RELEVANT REPRESENTATION SUMMARY

Project: East Park Energy

Applicant: BSSL Cambsbed 1 Limited

Your Ref: EN010141

Ref RAC/9611/2A	Rev. B
Drawn by AGM	Checked by AIF
Scales 1:10,000@A3	Date 09/2025

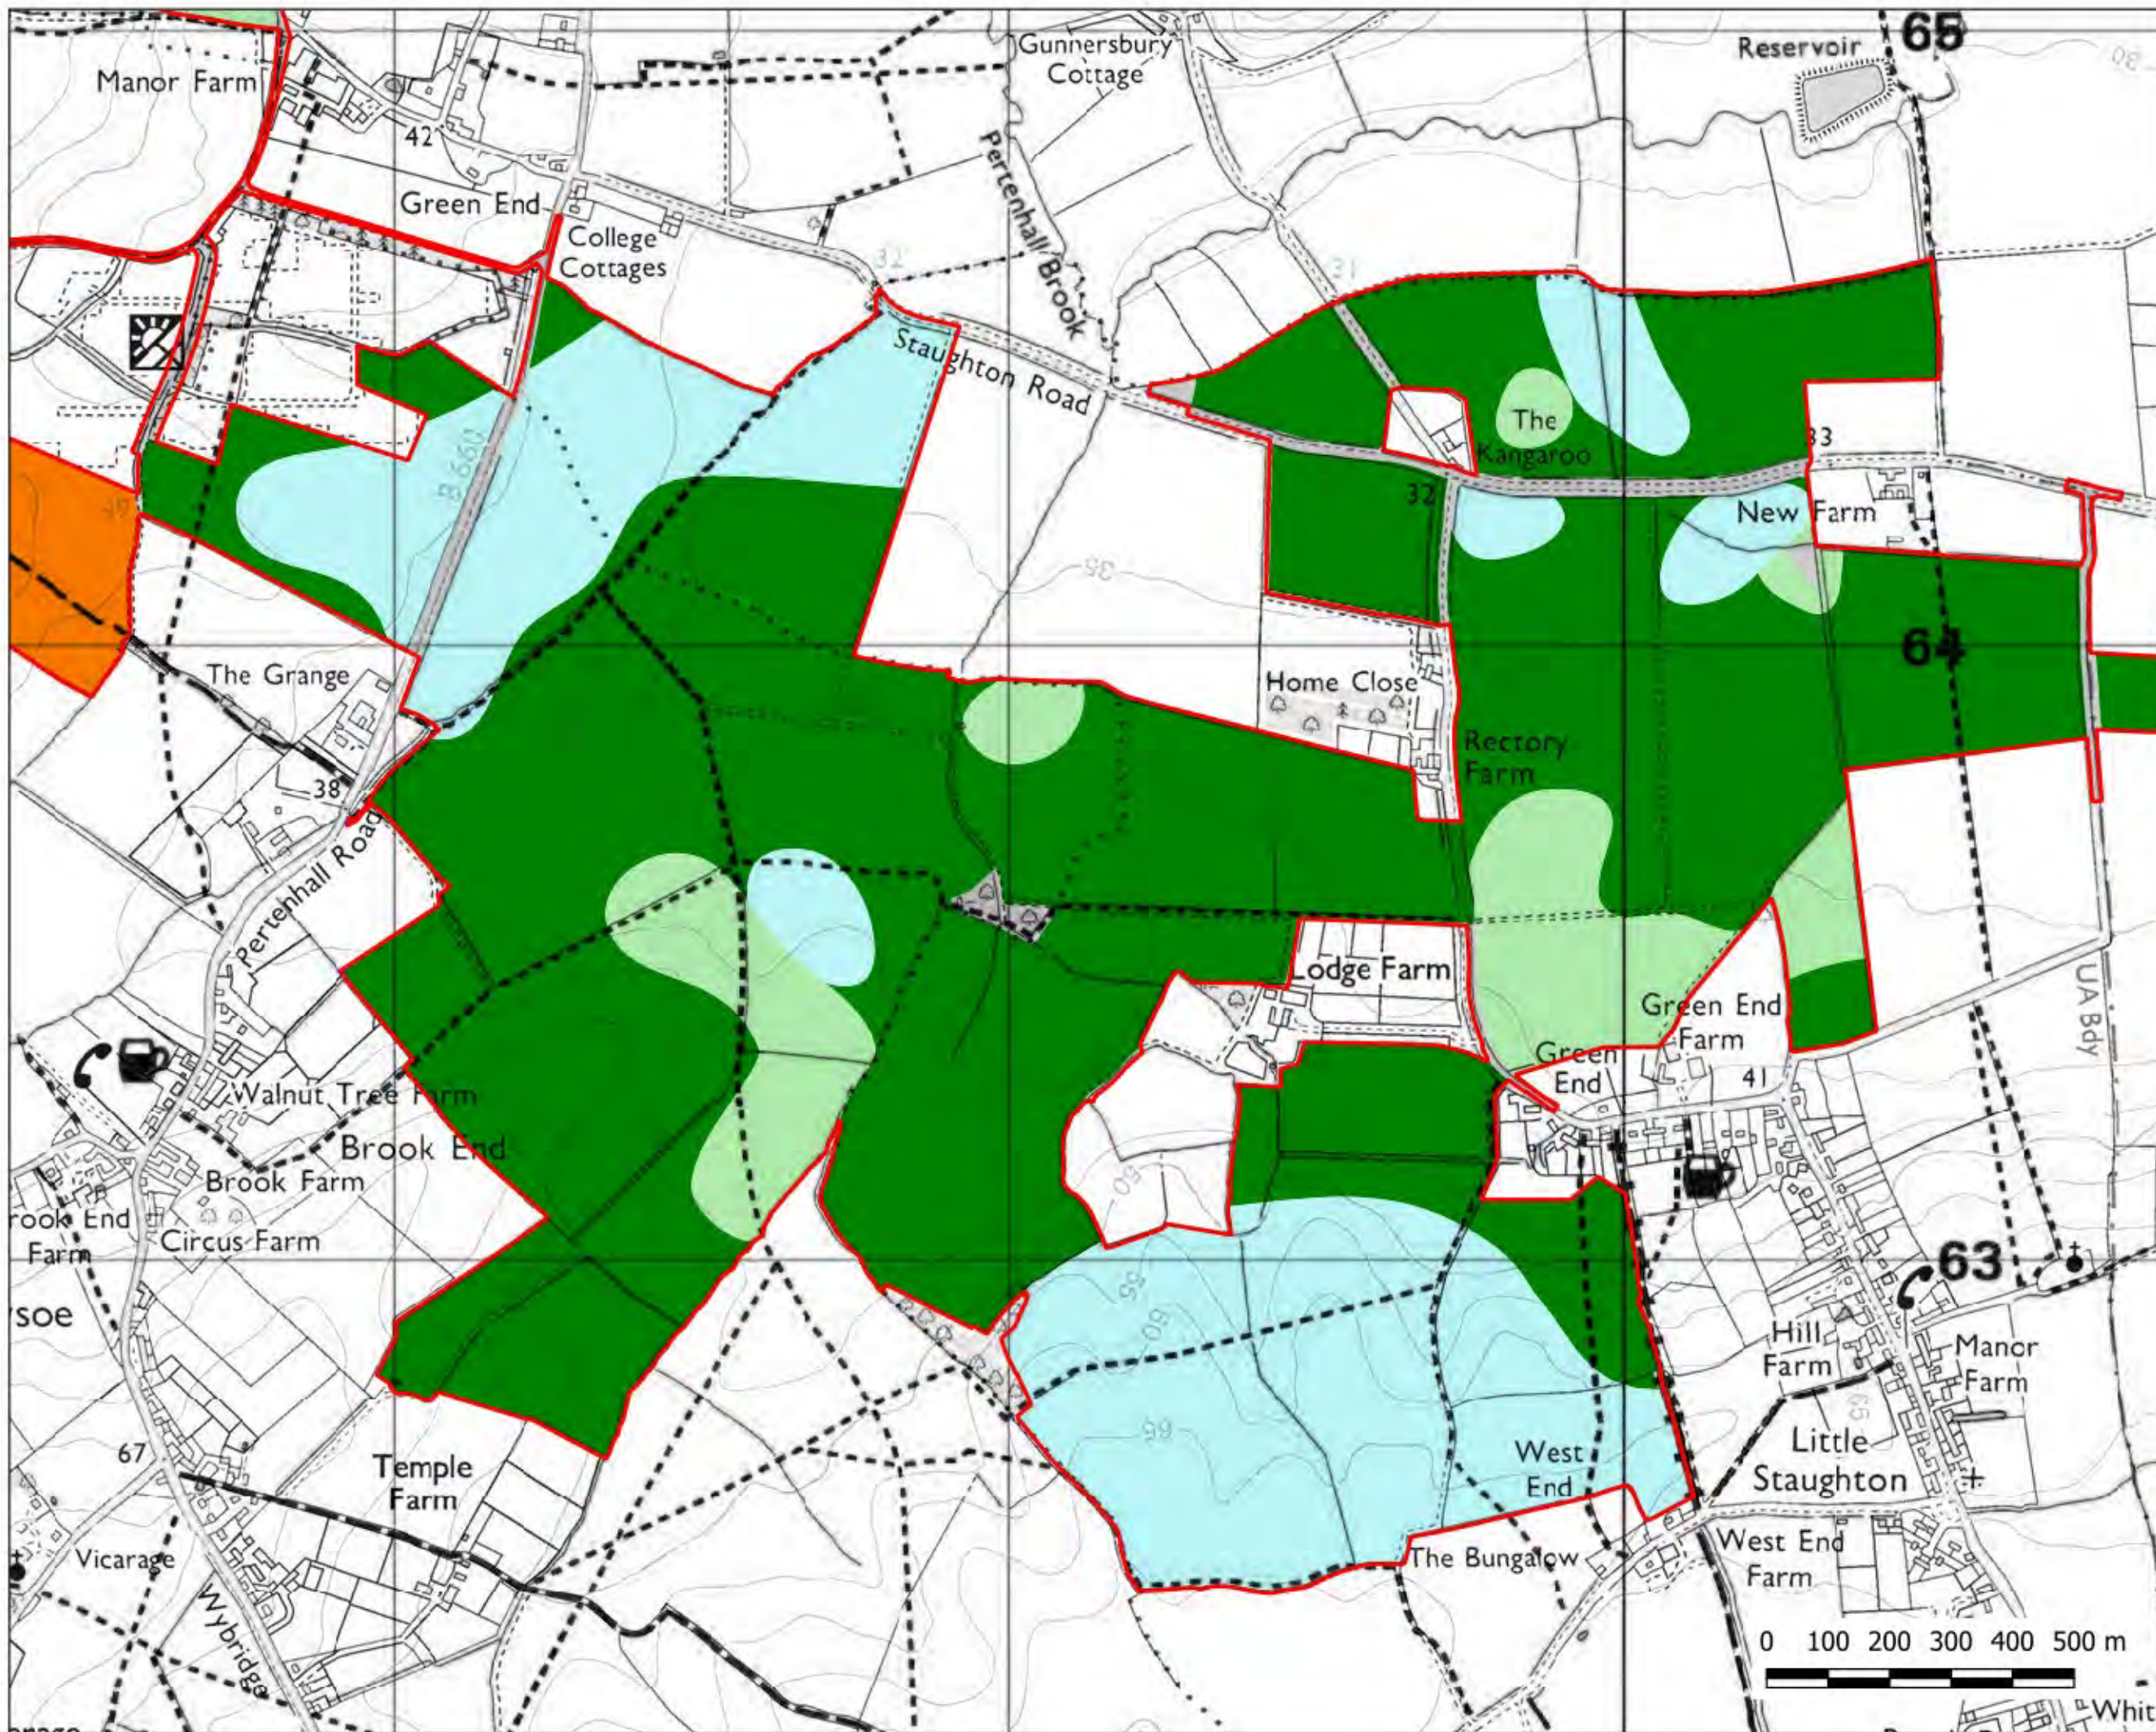
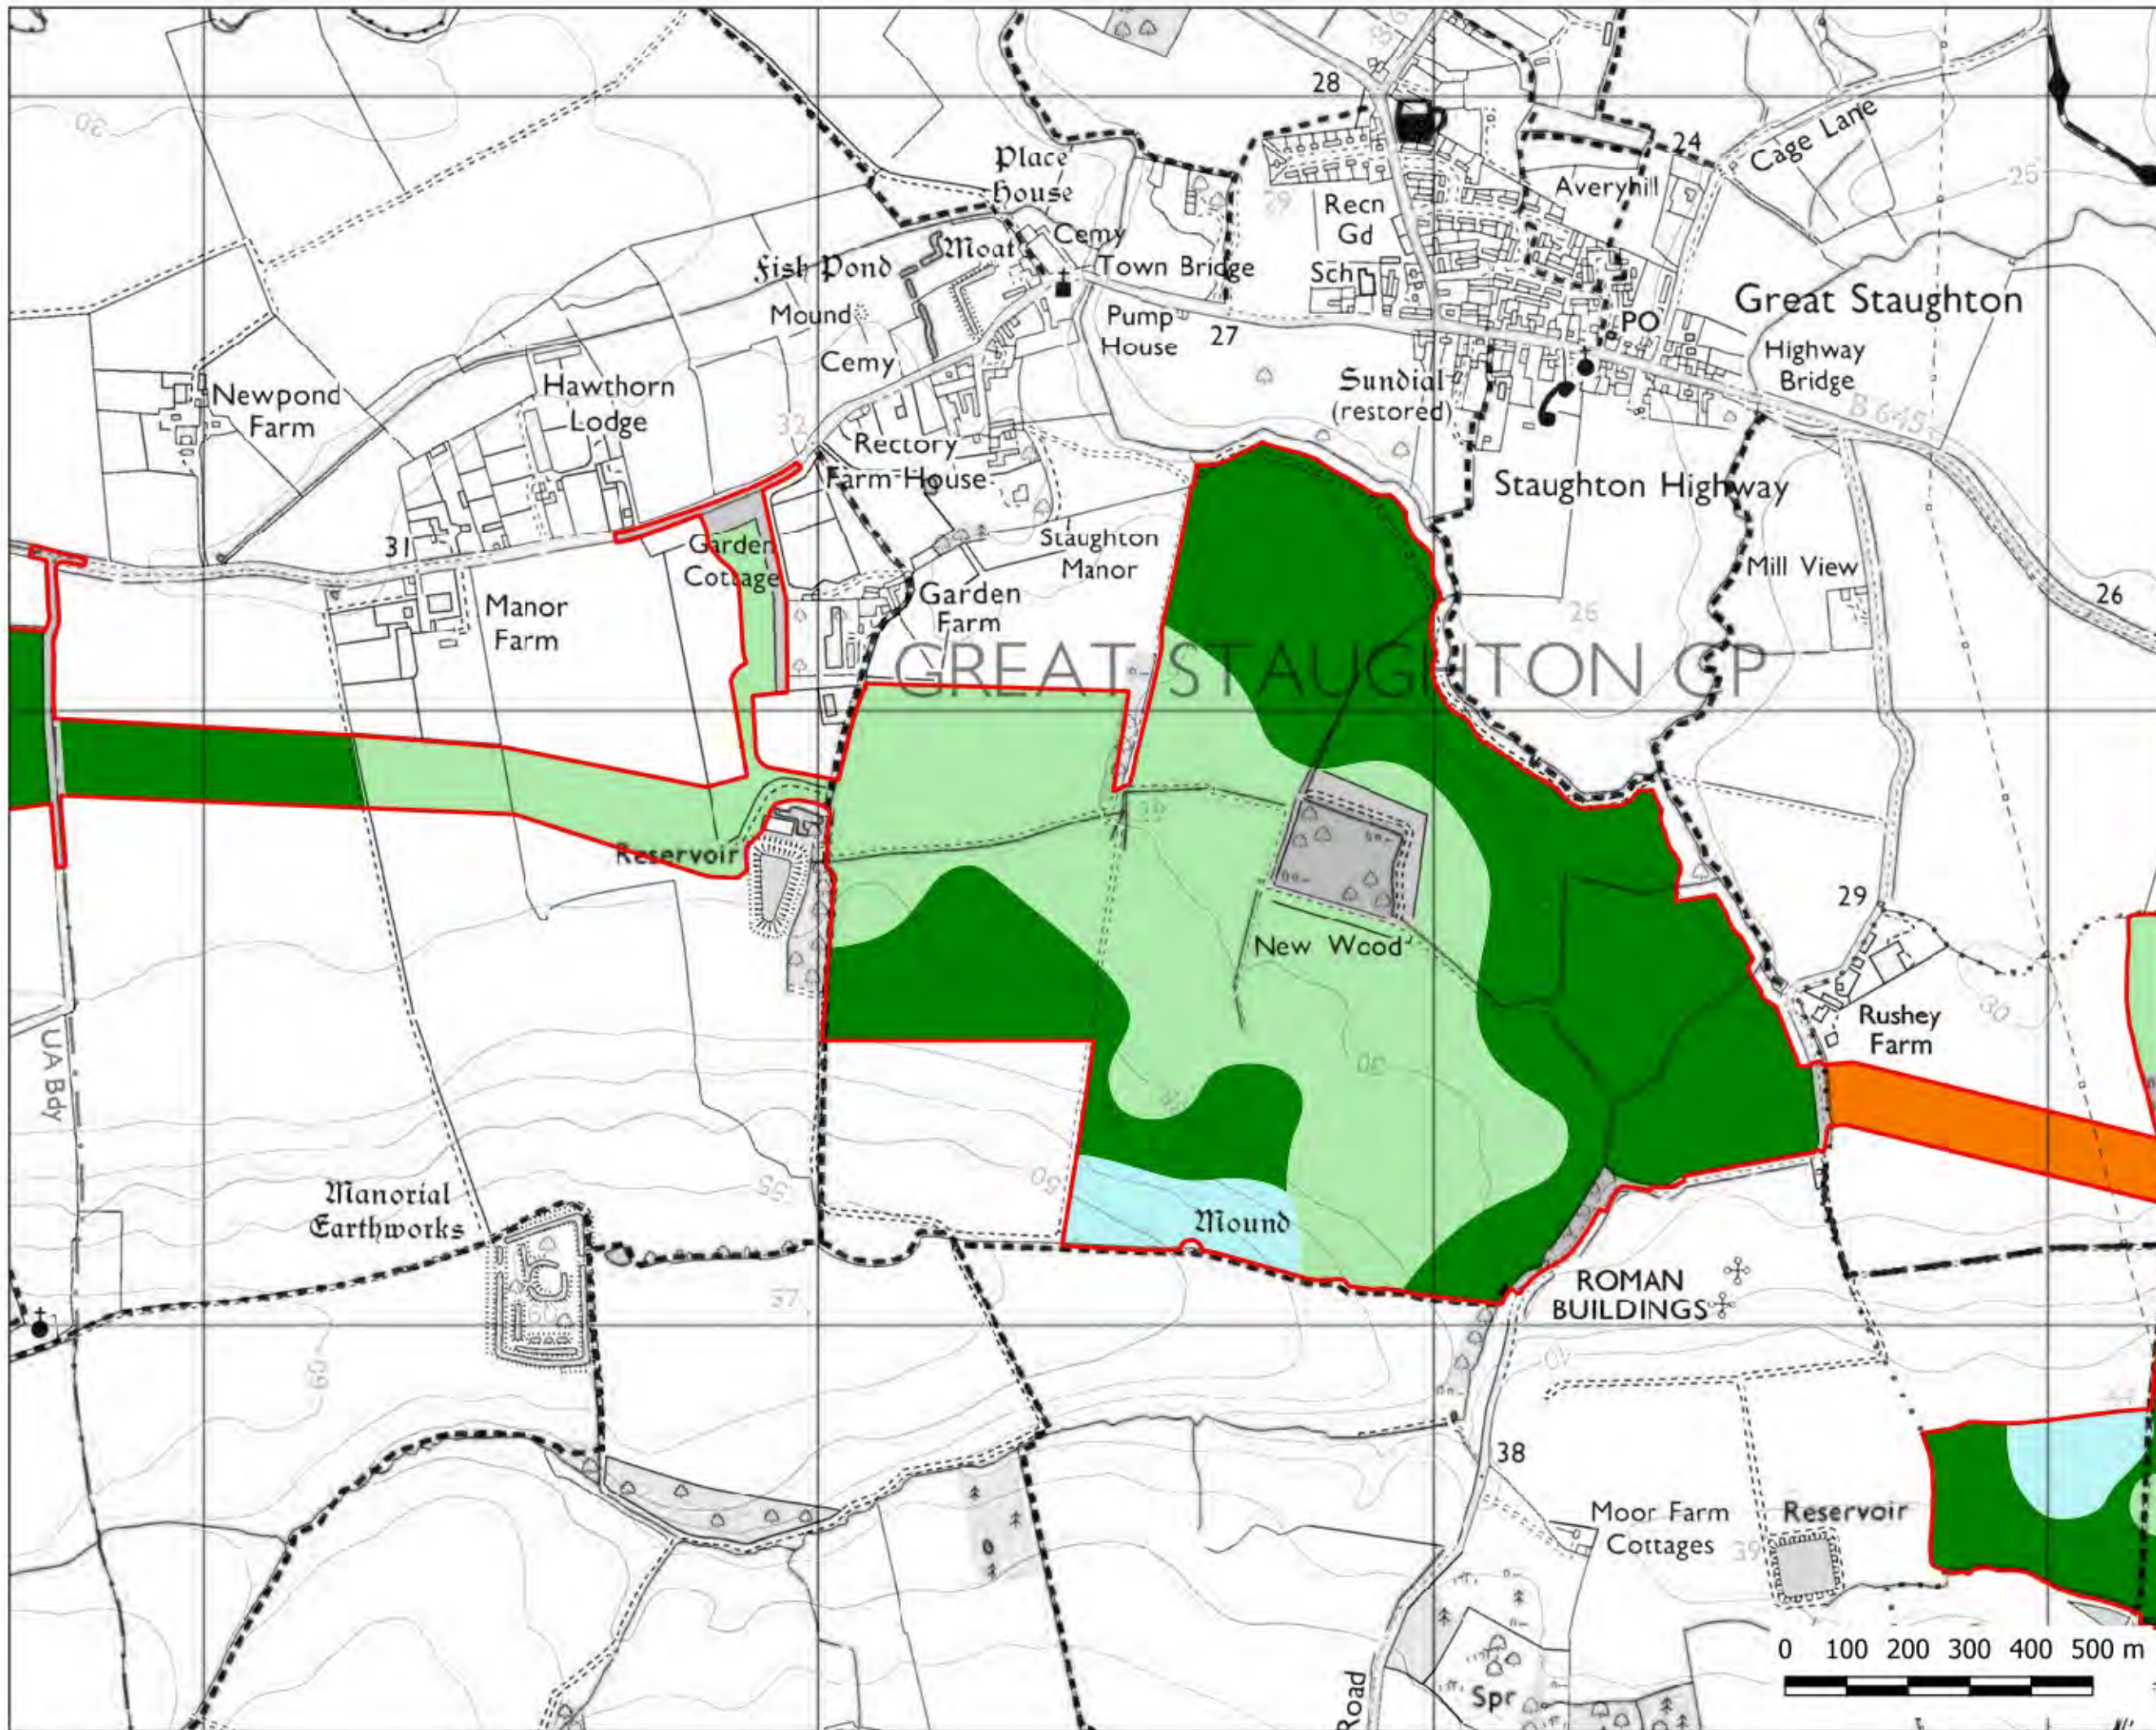
- missing Agricultural Land Classification (ALC) data for 5.4% of the site;
- underrepresentation of permanent land-use change resulting from woodland and hedgerow creation;
- potential understatement of effects on Grade 2 and 3a land;
- likely overstatement of beneficial soil effects during operation.

10.2 Further detail is required to justify conclusions on residual effects.
